Our Ref: R/180/18/HH
Your Ref:

Town & Country Planning Act 1990 (as amended)
Town & country Planning (Development Management Procedure) (England) Order 2015
Application for Planning Permission for Works or Extension to a Dwelling

Development Single storey rear extension.
Location 17 Kirdford Close Rustington

BLOCK PLAN

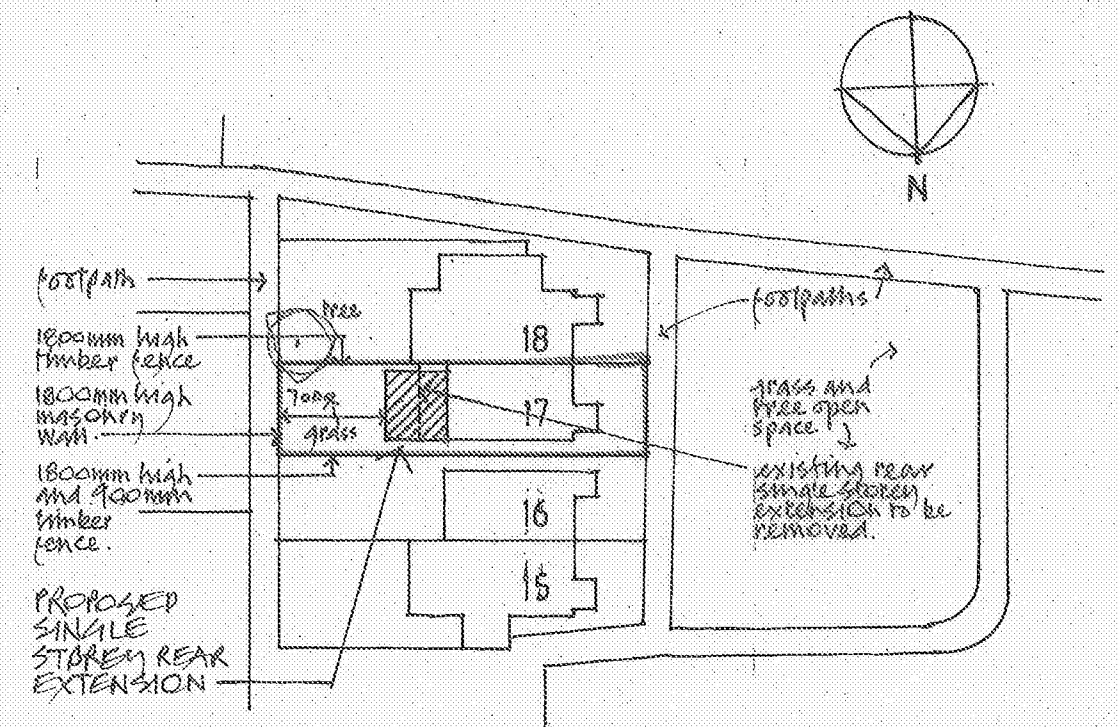
Block Plan Amend

Please provide measurements from the proposal to the rear boundary.
